Development Control
Ribble Valley Borough Council

Your ref: 3/2021/0268
Our ref:
Date: 19th April 2021

Re: Planning Application 21/0268

Address: Land south west of Ribblesdale Hall Sawley Road Chatburn BB7 4LD

SHEET: **PROPOSED SITE
PLAN ENTRANCE
TRACK**

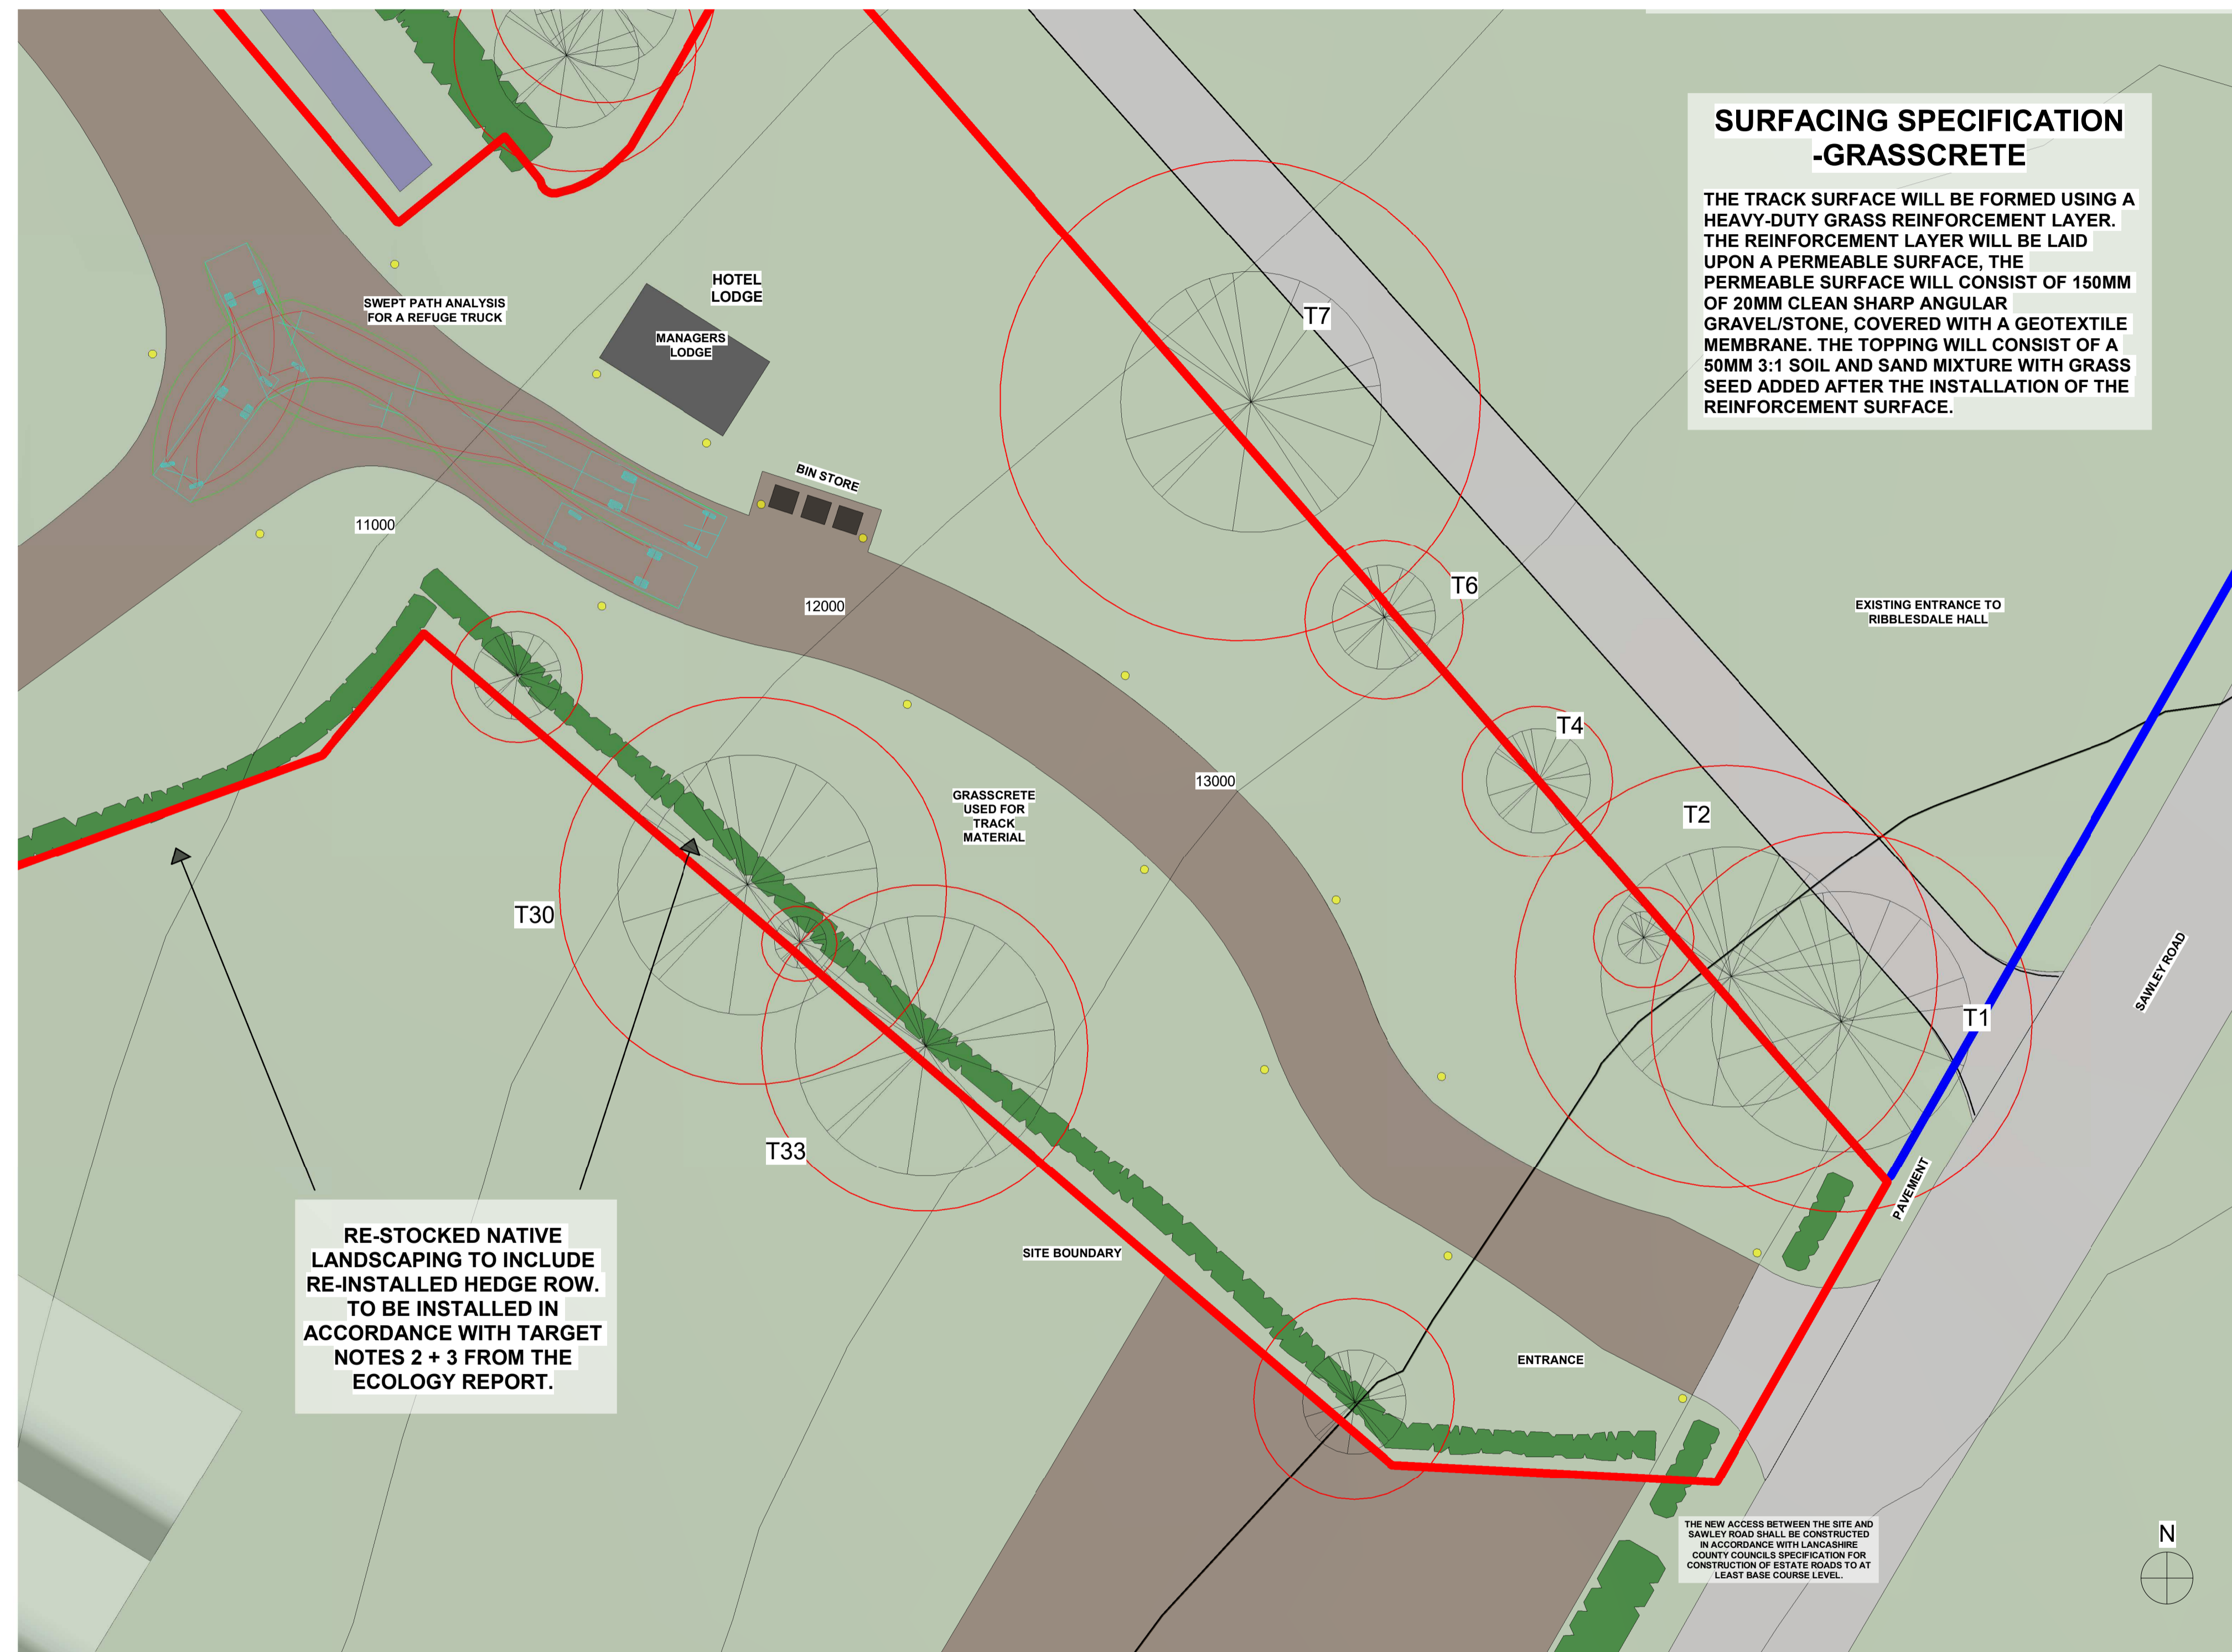
There are some concerns regarding the access and the refuse collection.

In order to support the application we would look for a widening of the access as detailed in the comments relating to the previous application 3/2021/0307, and a swept path analysis to ensure that a refuse collection vehicle is able to enter and exit the site in a forward gear.

The proposed access from the site to Sawley Road shall be constructed to a (minimum) width of 7 metres and this width shall be maintained for a minimum distance of 10 metres measured back from the nearside edge of Sawley Road

carriageway vehicle running lanes. Reason: To enable vehicles to enter and leave the premises without conflict, unhindered & in a safe manner without causing a hazard to other road users.

1 SITE ENTRANCE DEATIL
1 : 100

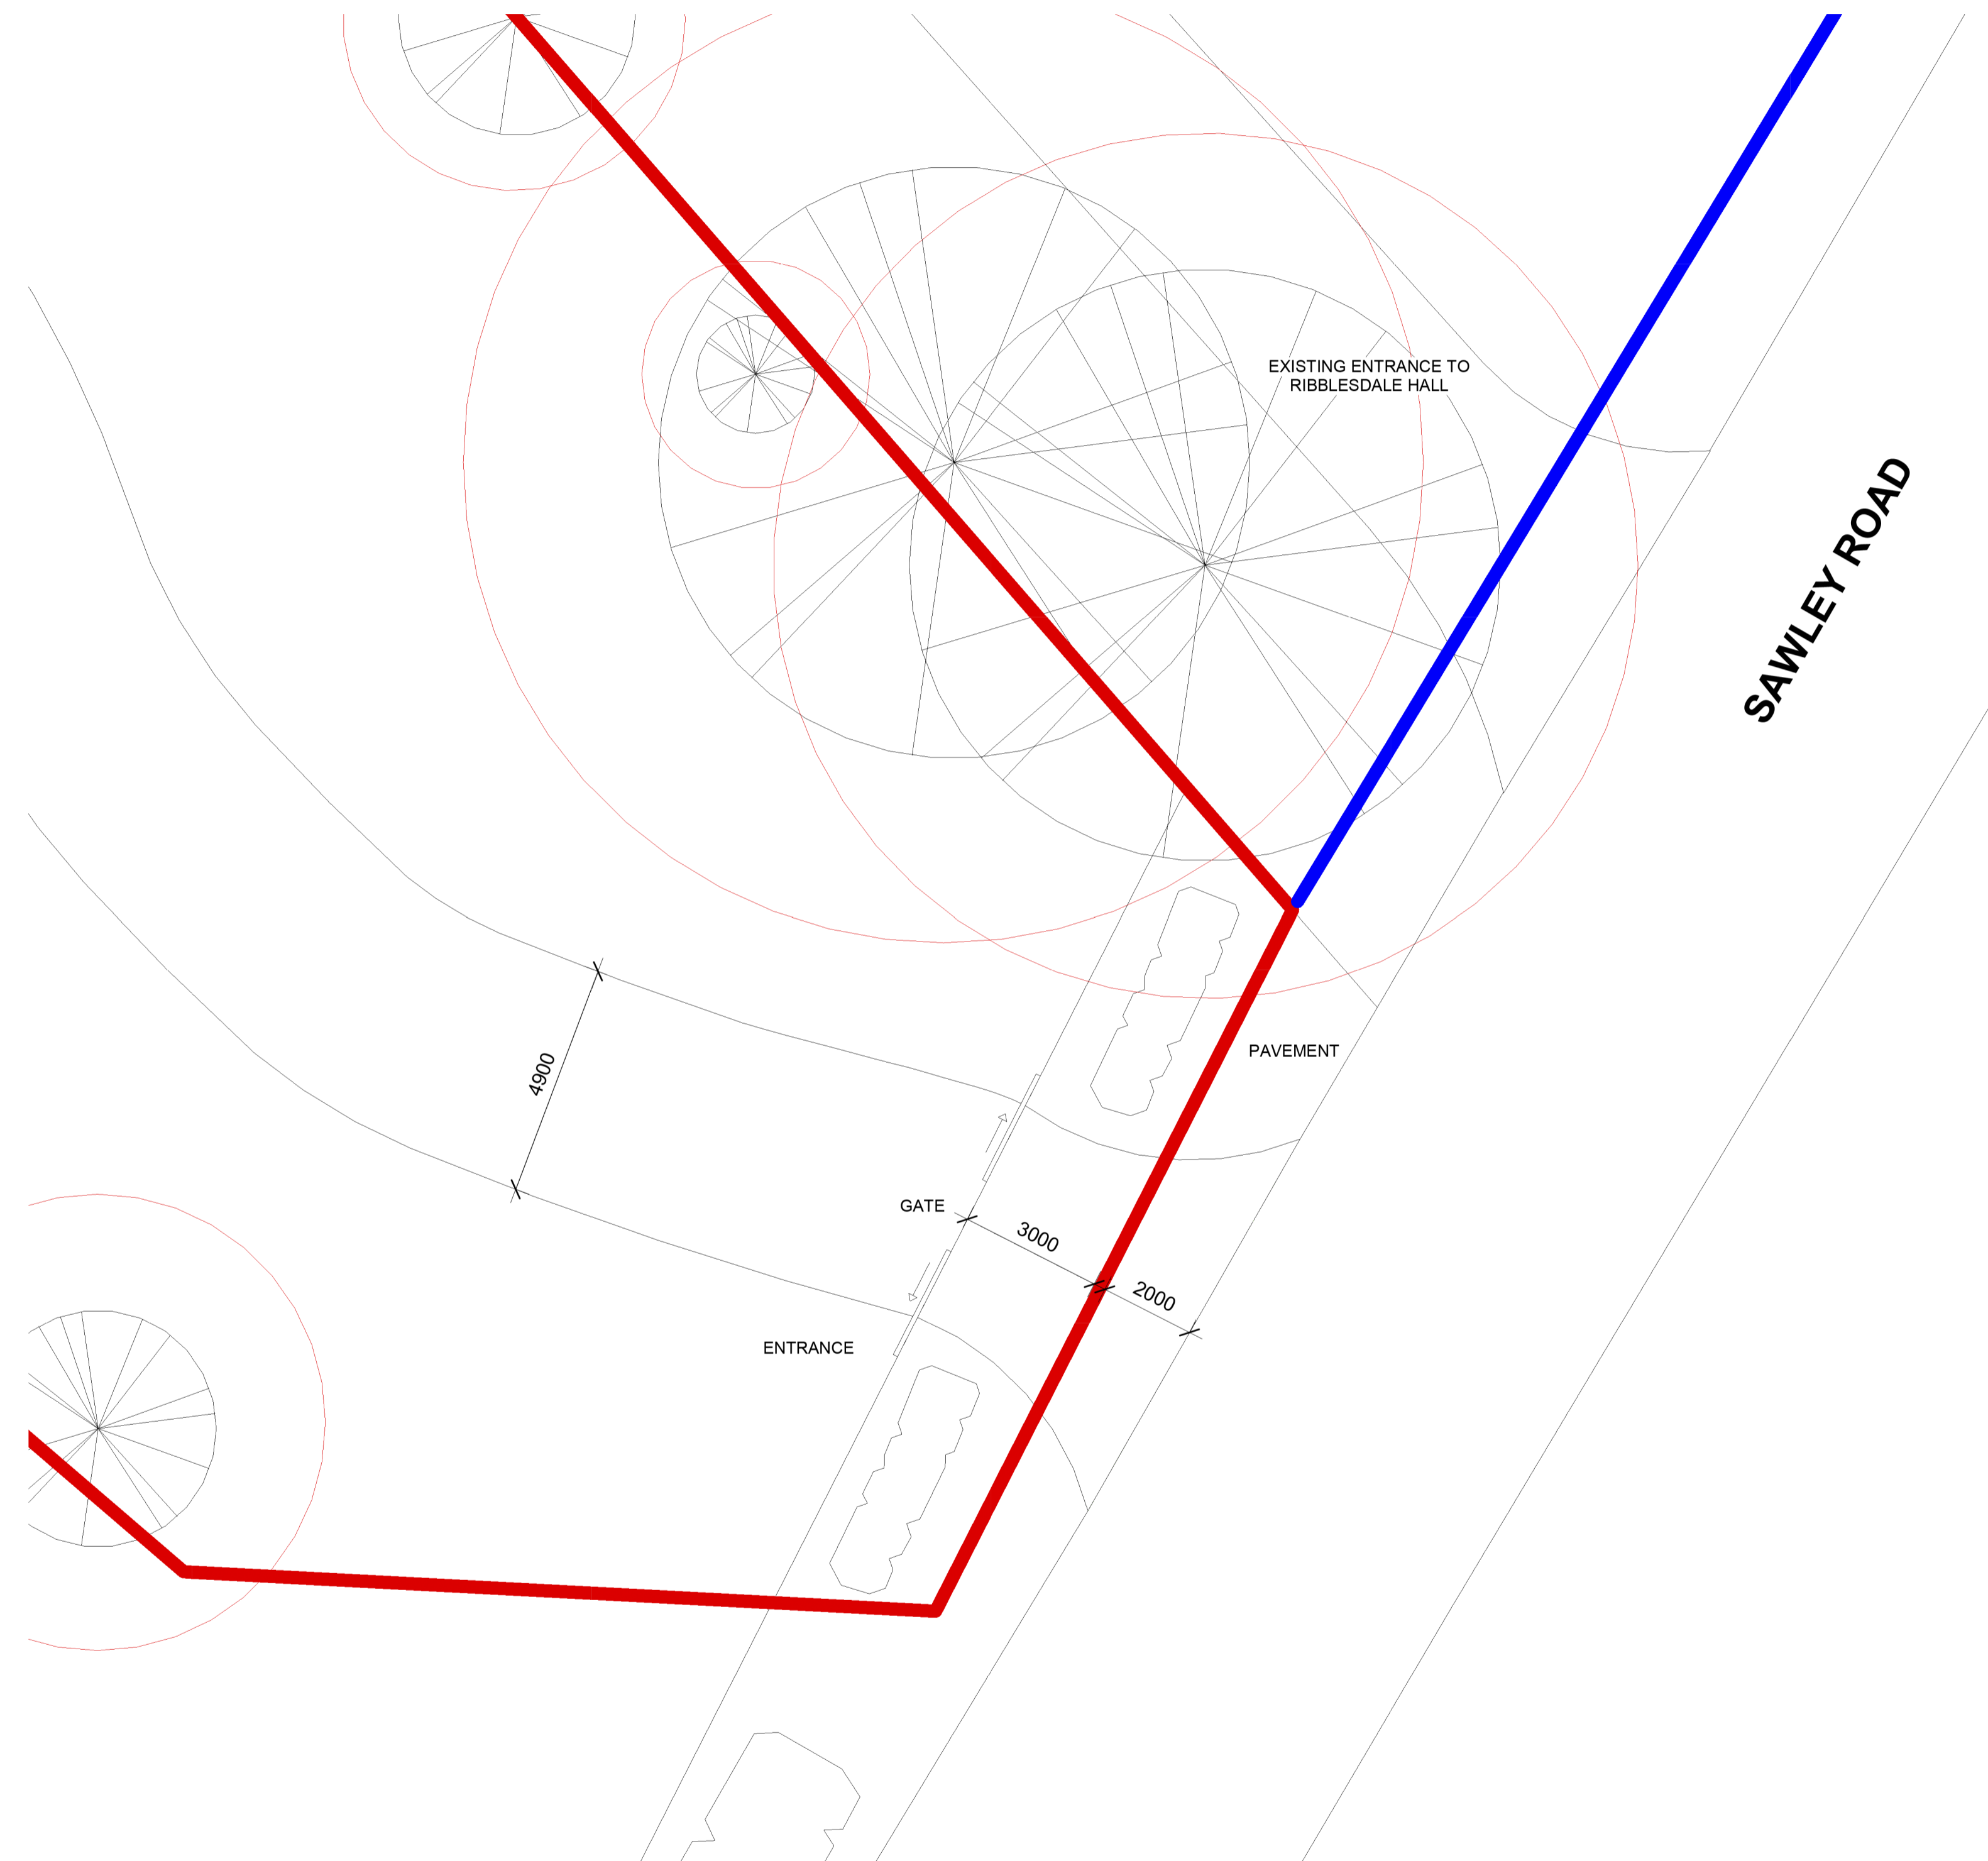
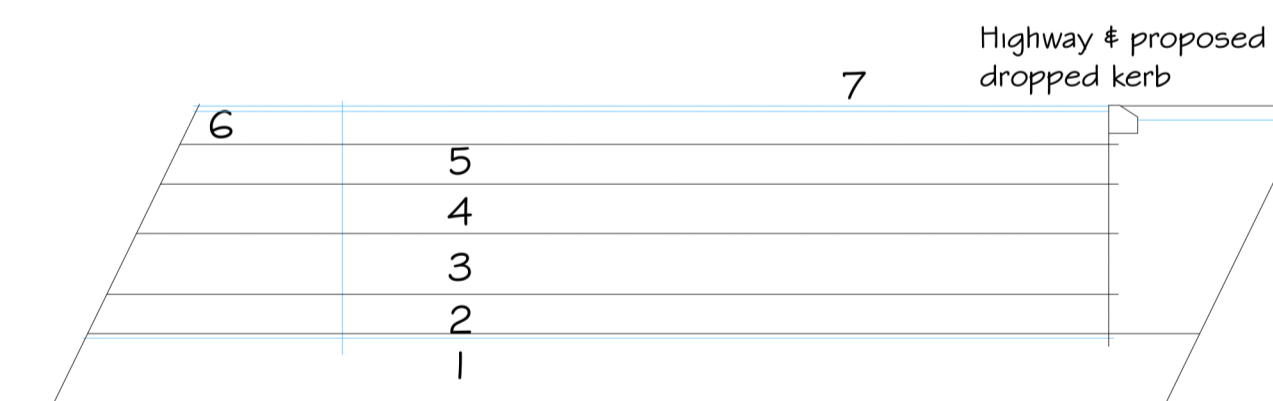
Before the access is used for vehicular purposes, any gateposts erected at the access shall be positioned at least 5m behind the nearside edge of the highway and visibility splay fences or walls shall be erected from the gateposts to the existing highway boundary, such splays shall be 45° to the centre line of the access. The gates shall open away from the highway. Should the access remain un-gated 45° splays shall be provided between the highway boundary and points on either side of the drive measured 5m back from the nearside edge of the highway.
